Planning Application Ref: BE/180/16/PL (2) Updated comments appear in red typeface -- 21.03.17

Location: Land adj. to 2 North Bersted Street, Bognor Regis

Description of works: Construction of 1 No two storey dwelling on a narrow storage yard

Project title			
North Bersted Street Bognor, West Sussex			
Drawing title			
Tree Constraints Plan			
Scale	Drawn	Date	
1:100@A1	GS	05.10.16	
Approved		JJ	
Drawing No	Revision		
LLD1051 / 01	00		
CAD Filename			
LLD1051/01/CAD

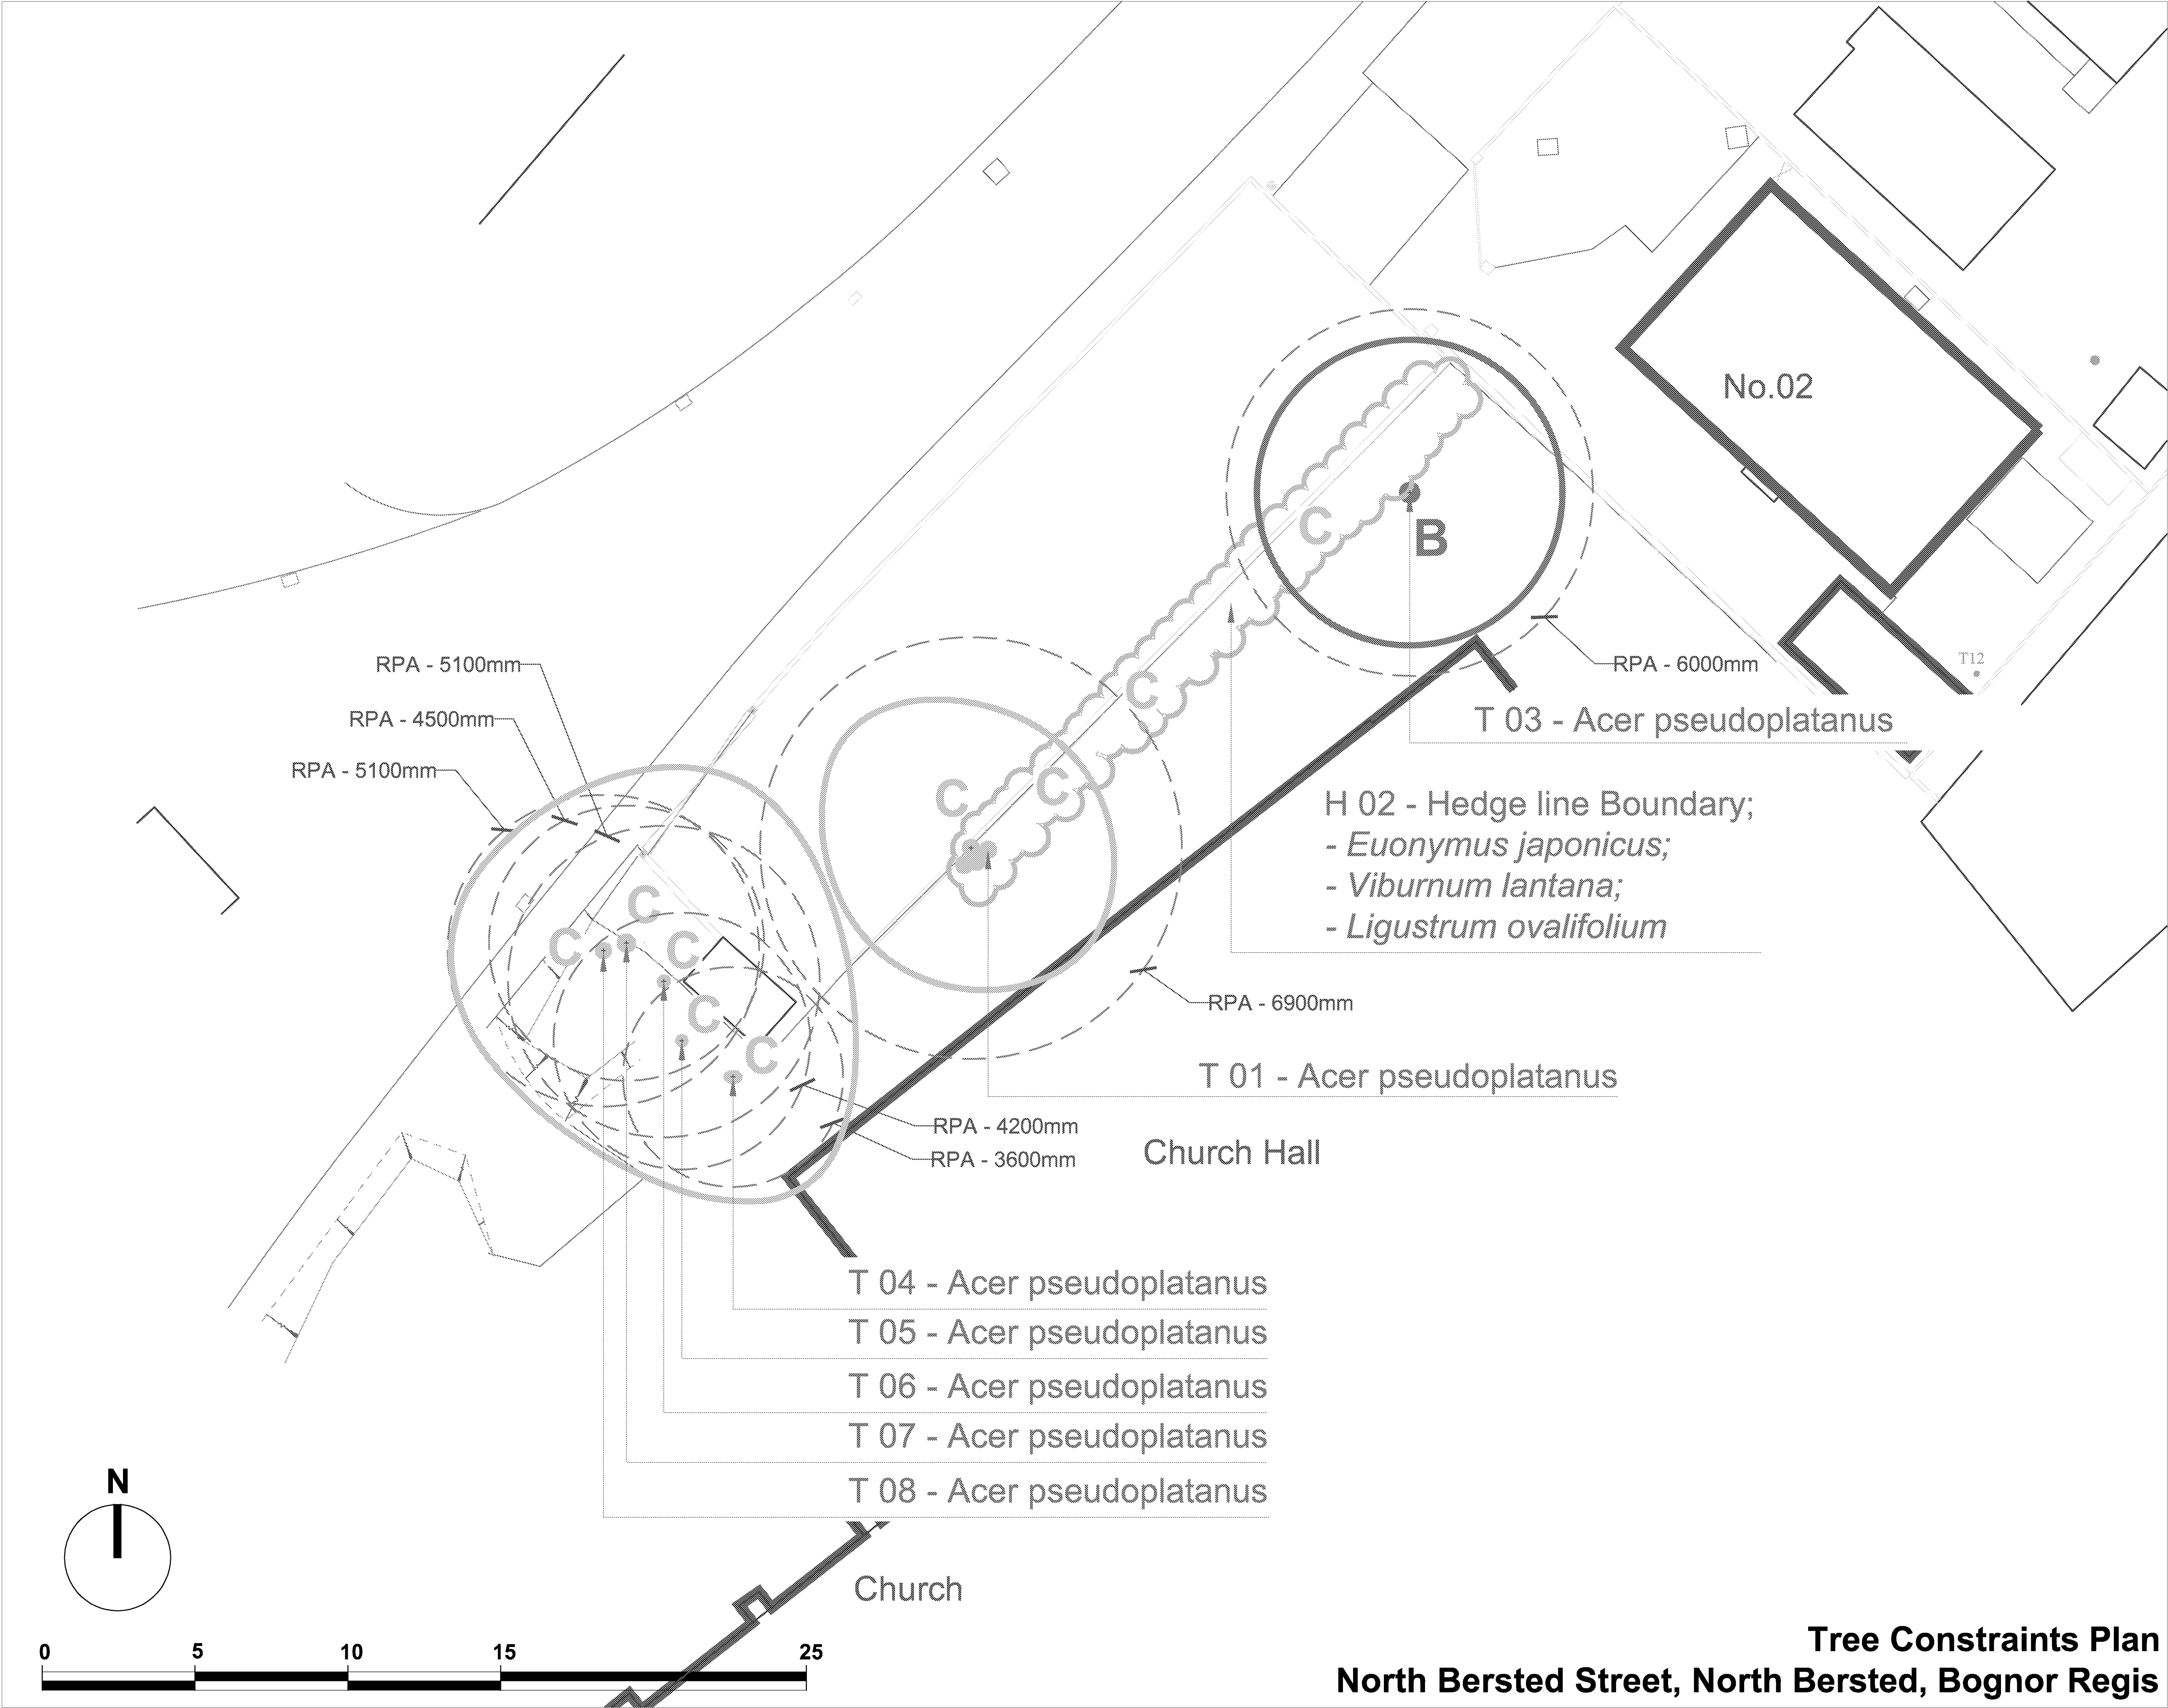
- The applicants have employed the service of **Lizard Landscape Design** who have prepared a Tree Survey & Root Constraints report with a Tree Constraints Plan but at this juncture no Arboricultural Method Statement Report complete with Tree Protection Plan has been submitted – all of which is required by BS5837:2012 in support of an application where trees are within influencing distance of proposals. There are no trees on this site but it is dominated and overshadowed by 8 self-sown off-site Sycamores that are young trees with significant potential for growth and expansion in the future.
- These are not trees of quality in the landscape but the fact remains that they exist and are not under the direct control of the applicants therefore they pose a constraint to the development proposed.

- The tree survey and constraints data is satisfactory.
- I do not doubt that the new dwelling can be constructed without too much damage to the root systems but they will need to provide a detailed Method Statement & Tree Protection Plan report to justify this. Lizard Design have now submitted a Method Statement and I agree that with the combination of levels differences and the low retaining wall very little root if any will be found when they are excavating the site so its construction is feasible without detriment to tree roots. The site is so small that there is no room for protective fencing other than around the perimeters but we will need to see a plan showing this i.e. a Tree Protection Plan.

- I find that the base tree constraints data submitted in support of this planning application is fine as far as it goes but given the complexities of the build process there will be a need for them to supply further information in support of the application in the form of a detailed Method Statement & Tree Protection Plan report. We will still require a Tree Protection Plan.
- As things stand I would have to register an **OBJECTION** to this scheme on the grounds of 'pressure to prune or fell the off-site trees. I see no reason to alter my decision on this as they have confirmed that the trees would have to be topped out and crown lifted just to facilitate the development in the first instance.
